WISWELL PARISH COUNCIL

Planning Application No: 3/2012/0286

Planning Application No: 3/2012/0287

Proposal: Installation of freestanding totem sign

PLAN VIEW 1/20

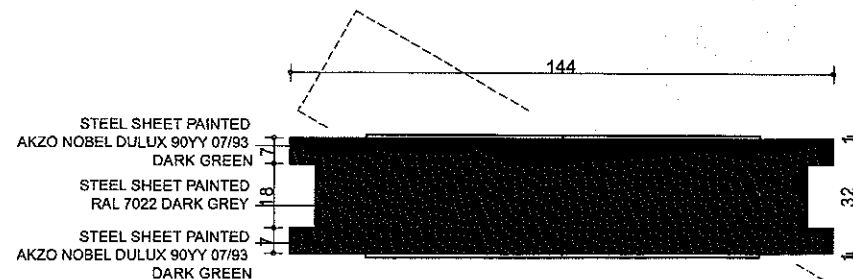
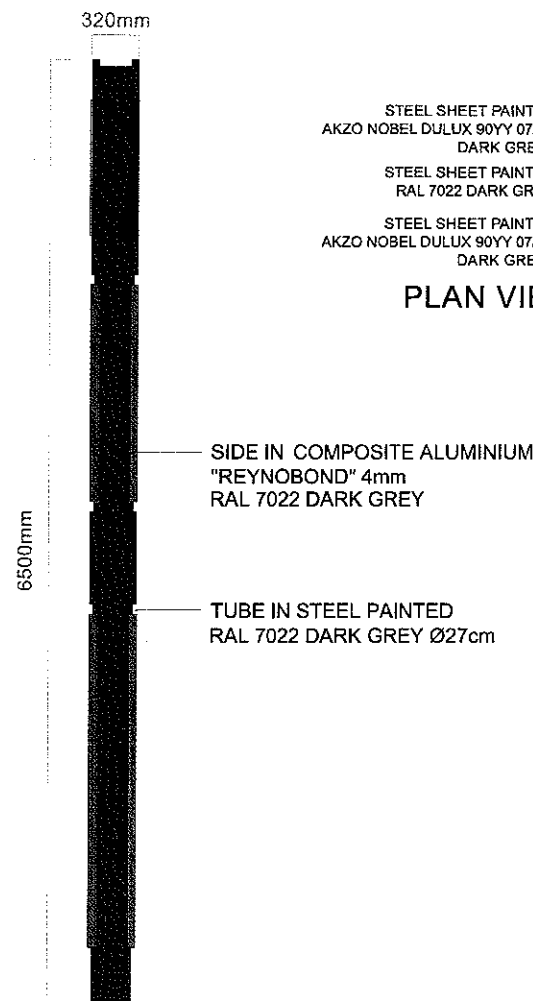
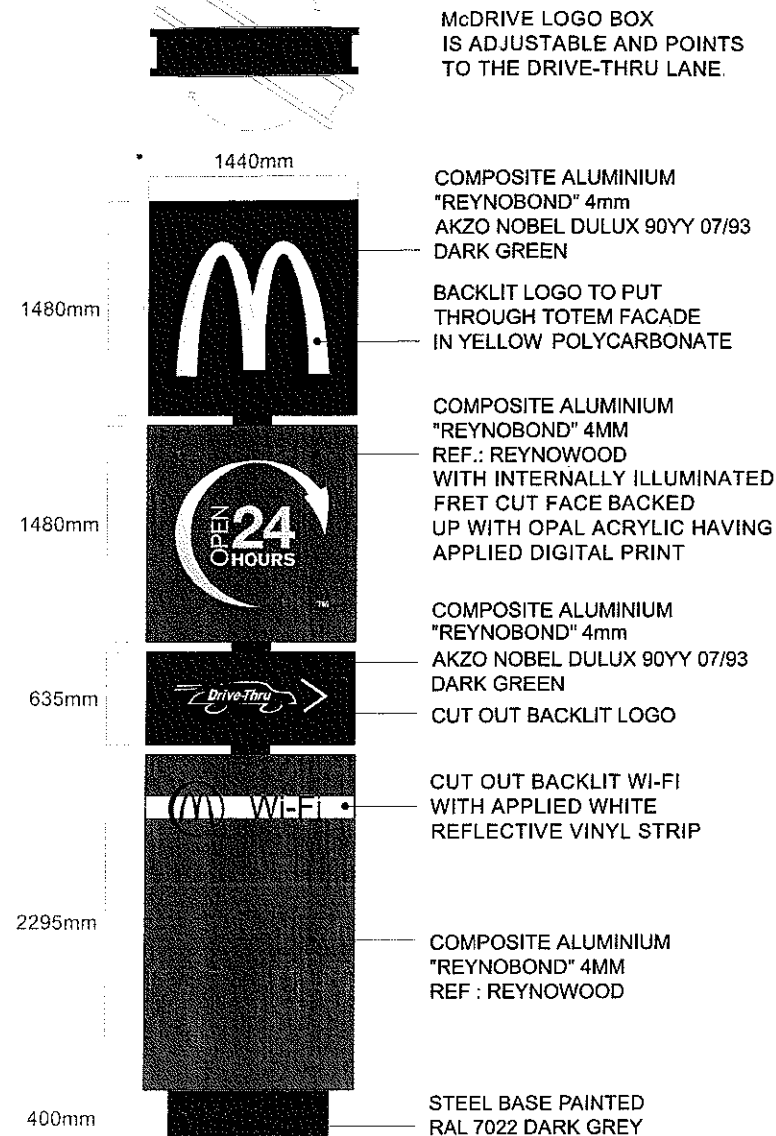
The Councillors have strong objections to the installation of a freestanding 6.5m totem sign. They consider the illuminated totem sign to be unnecessary, obtrusive and far too tall for a countryside location, more in keeping with Blackpool than the Ribble Valley.

DRAWING TITLE :-
Block Plan
APPLICATION 2- TOTEM 6.5m

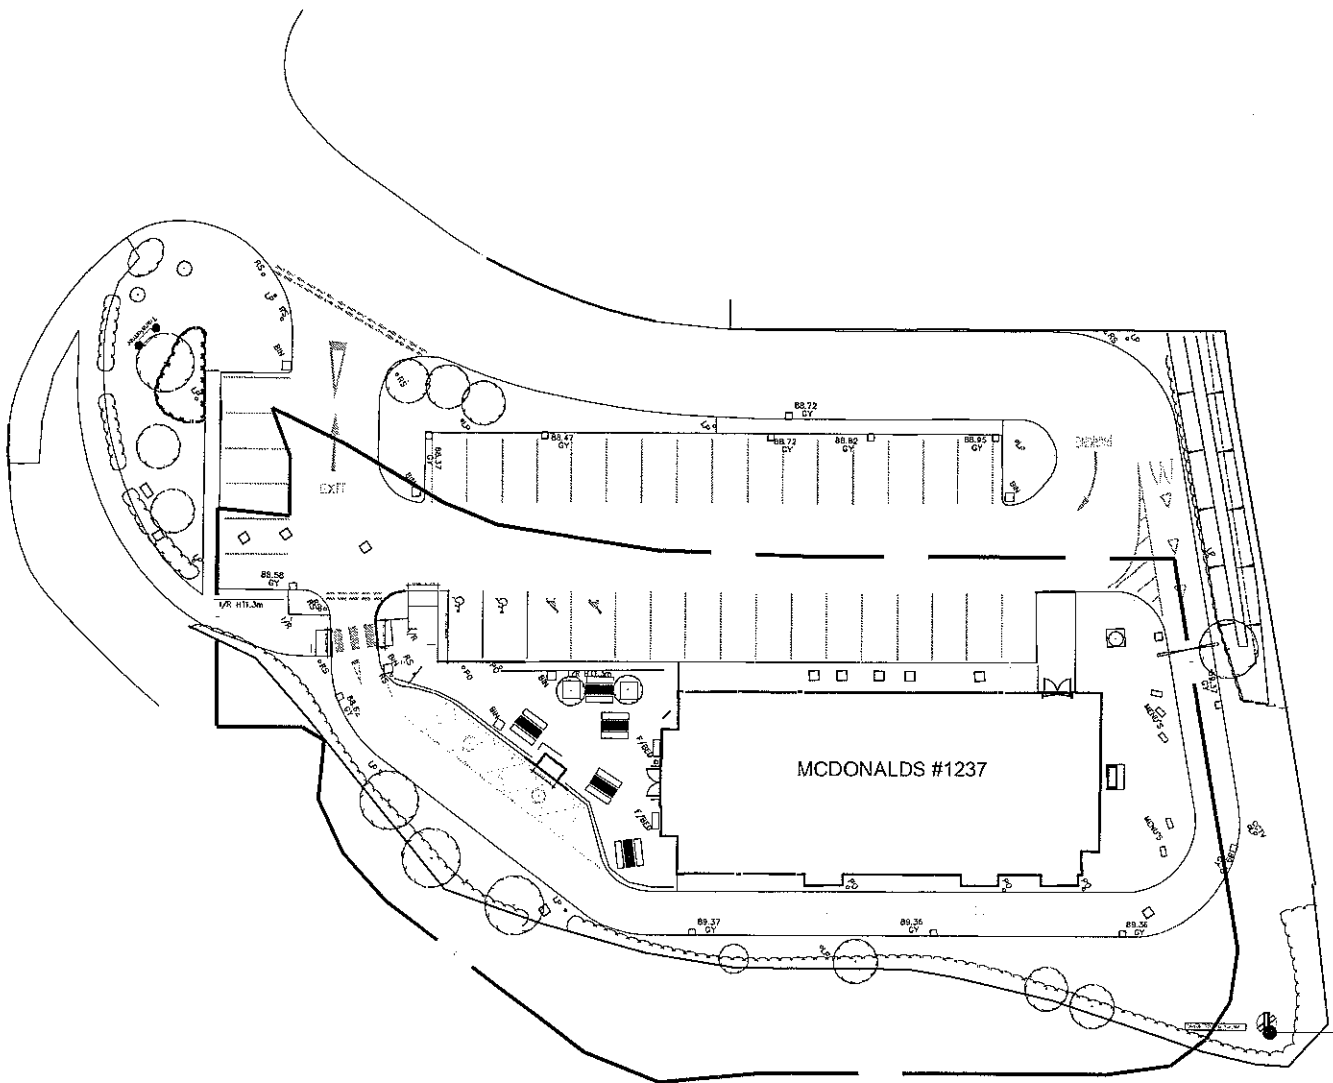
In addition, the Councillors are concerned that the totem sign would be distracting to motorists and that such a high sign in this location would be subject to winds and have the potential to cause accidents on the A59.

It is noted that a similar planning application was refused in 2006 as it was considered to be contrary to Policies G1, ENV3 and RI7 of the Ribble Valley Districtwide Local Plan. The sign was considered to be advertising, unrelated to highway requirements and positioned to attract the attention of drivers which would lead to the detriment of highway safety. It was also seen as an incongruous element in the locality and detrimental to visual amenity. Furthermore, approval would create a precedent for similar signs which would have a cumulative effect on the visual amenities of the locality. The Councillors believe that these reasons for refusal are still valid and should be applied to the current application.
